**Consultation Response from KC,  
 Strategic Housing**
**2023/91116 Land off, Primrose Lane, Hightown, Liversedge, WF15**
**Erection of 77 dwellings, with access from Darley Road and associated works**
**Date Responded: 26/02/2024**
**Responding Officer: Kate Crozier**
**Responding Ref: SH/23/91116**

PRIMROSE LANE
 PROPOSED SITE LAYOUT

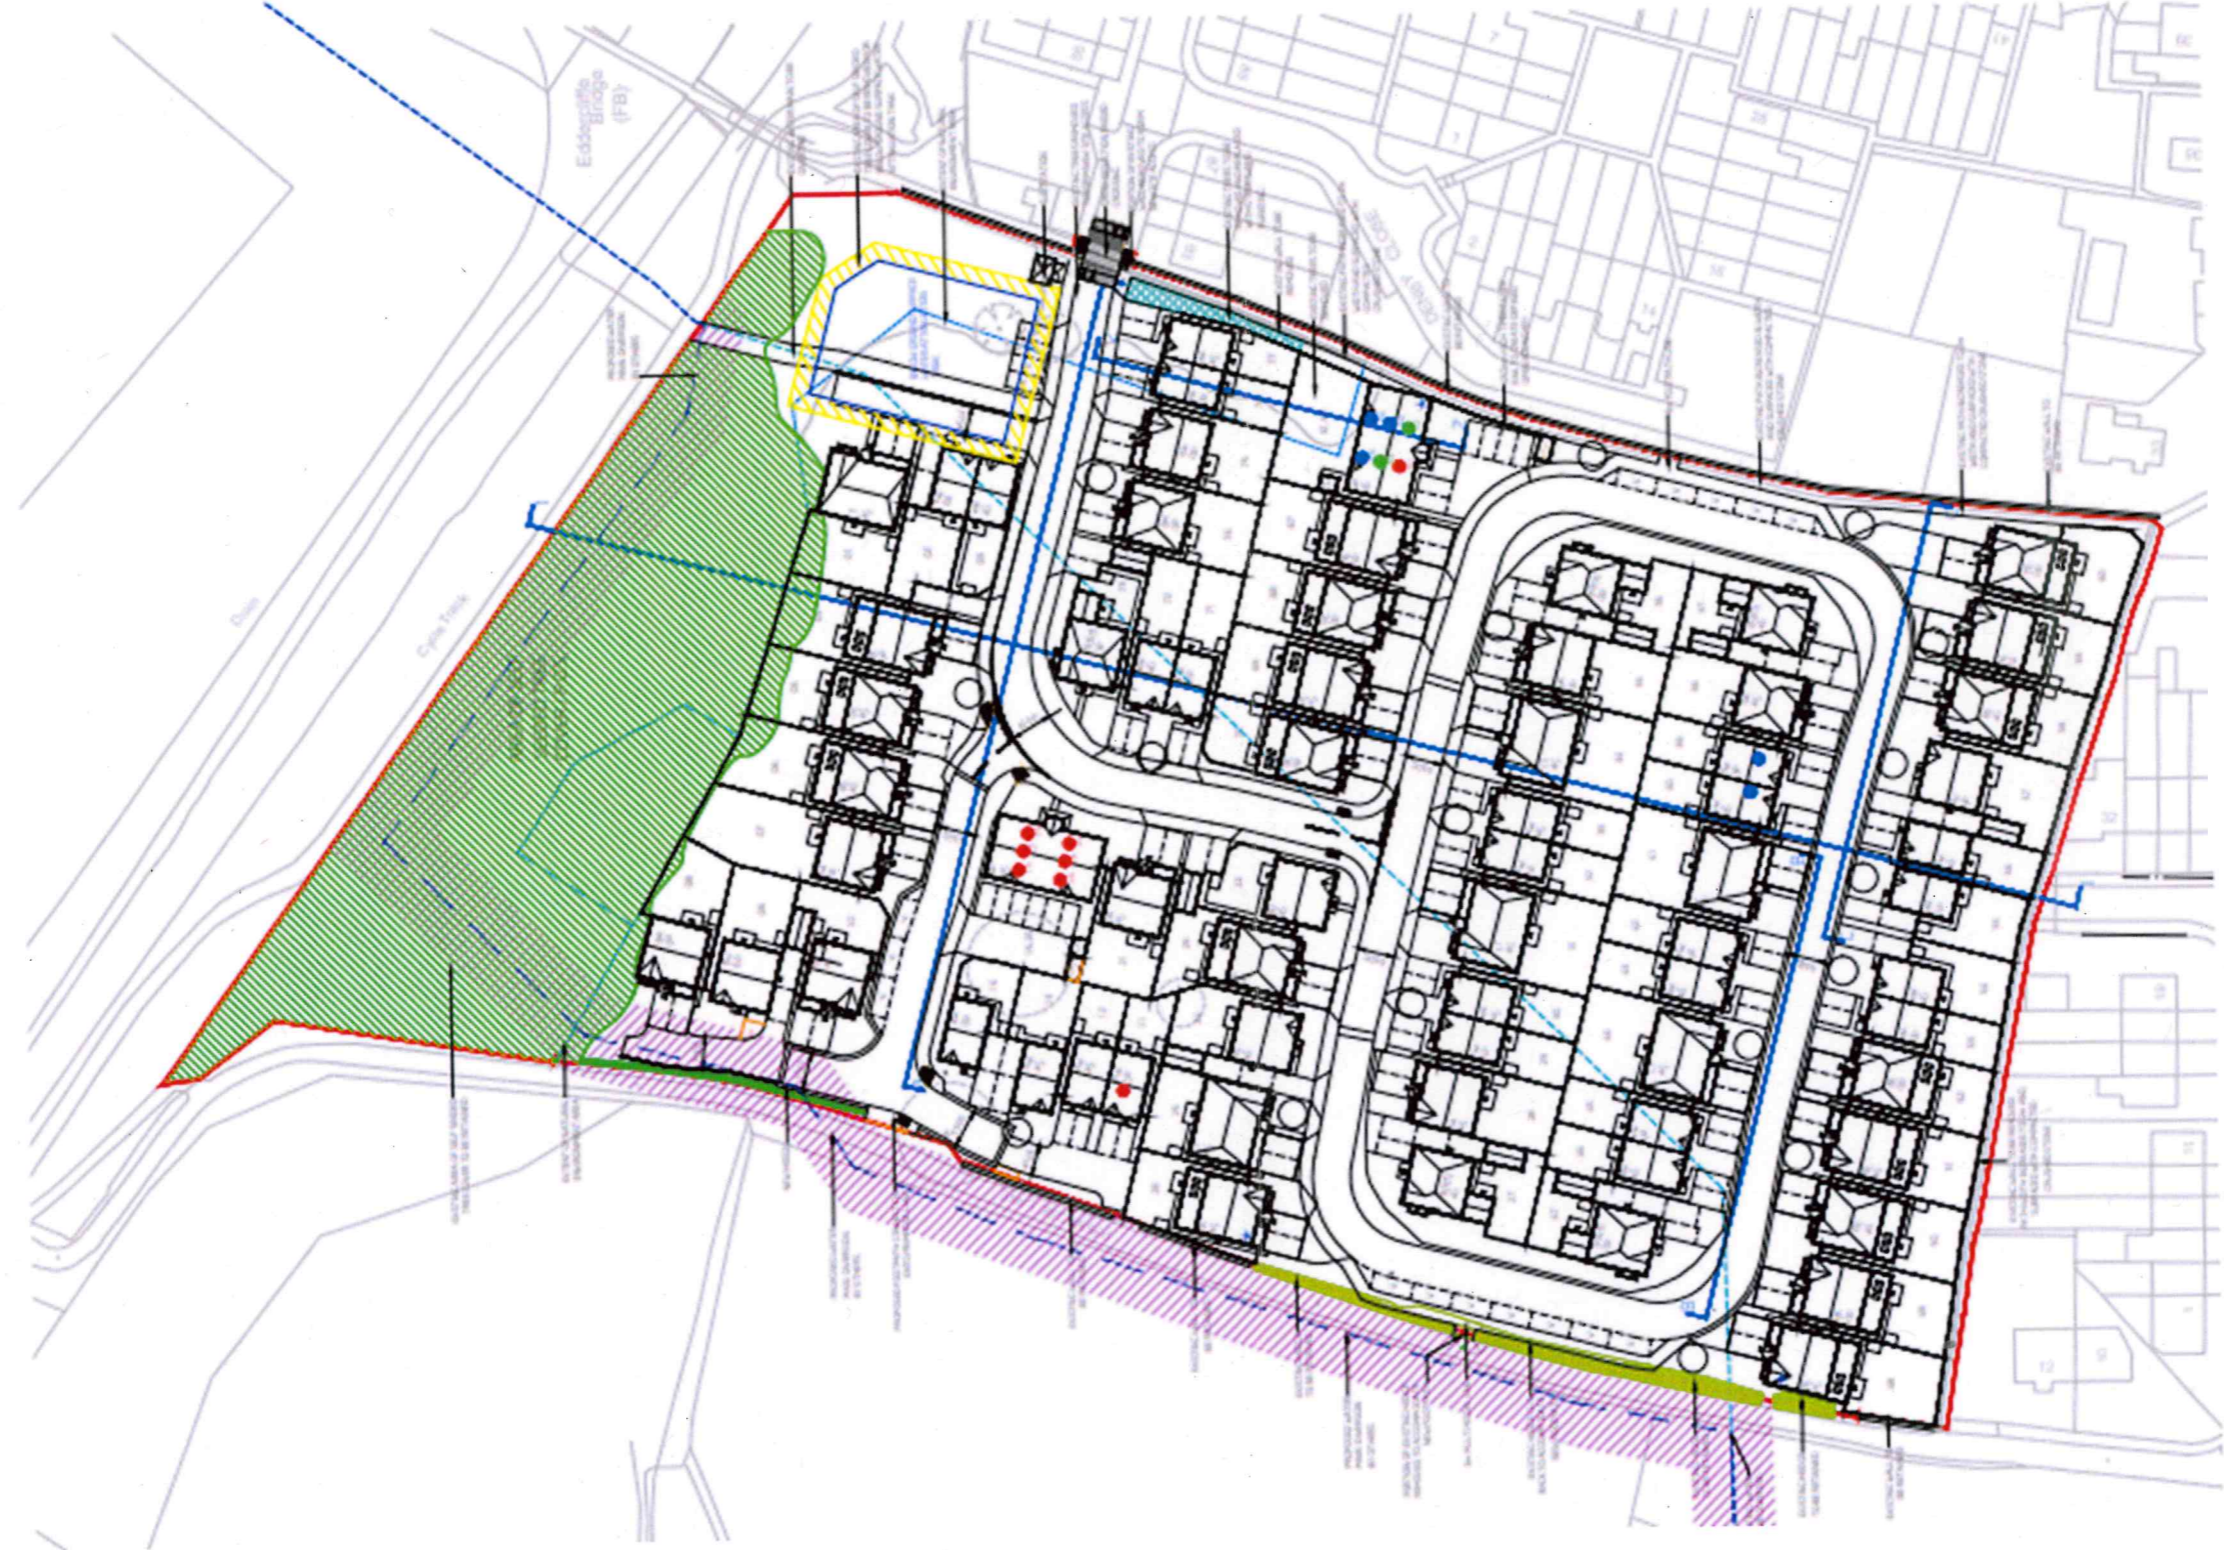
The proposed layout does not currently show any affordable homes in the development therefore, Strategic Housing are unable to comment.
